STERLING RANCH ROAD CROSSING

GRADING AND EROSION CONTROL PLAN

MAY 2022

CCES Responses

STERLING RANCH ROAD CROSSING
GRADING AND EROSION CONTROL PLAN
EROSION CONTROL DETAILS

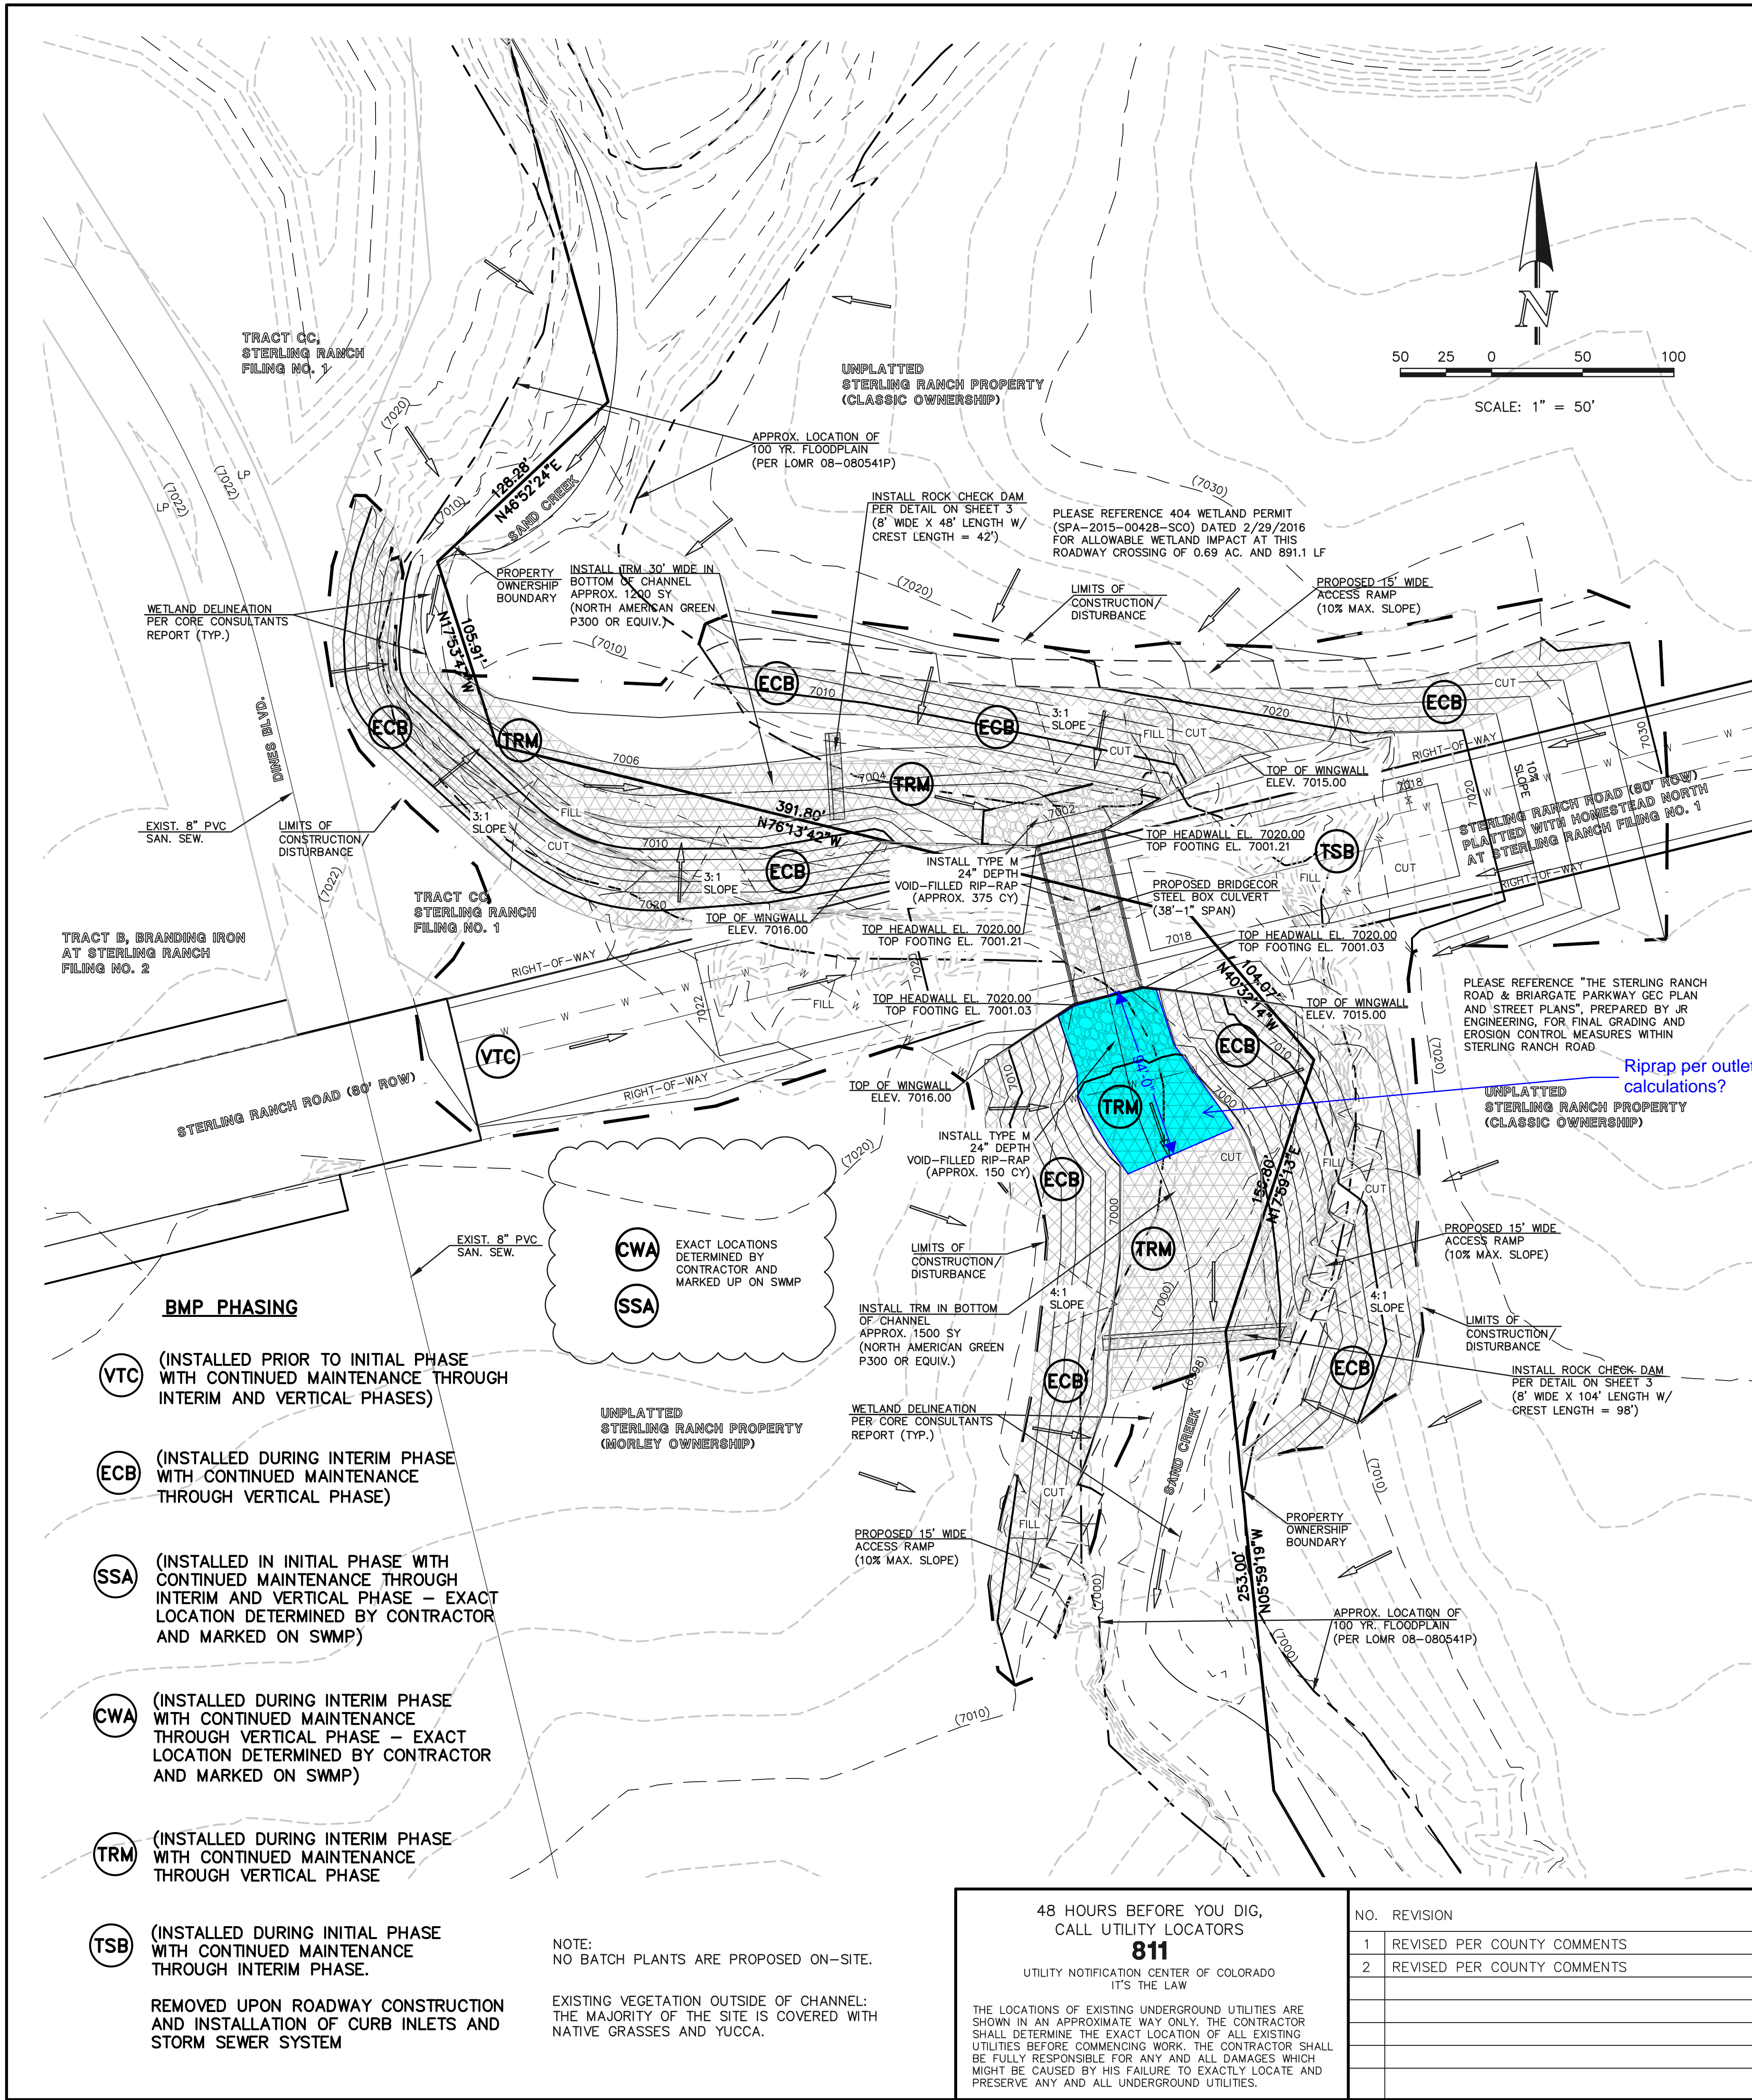
Item Z. Include details for the following BMP's. Examples of acceptable details for each are provided:

Added details on sheet 3
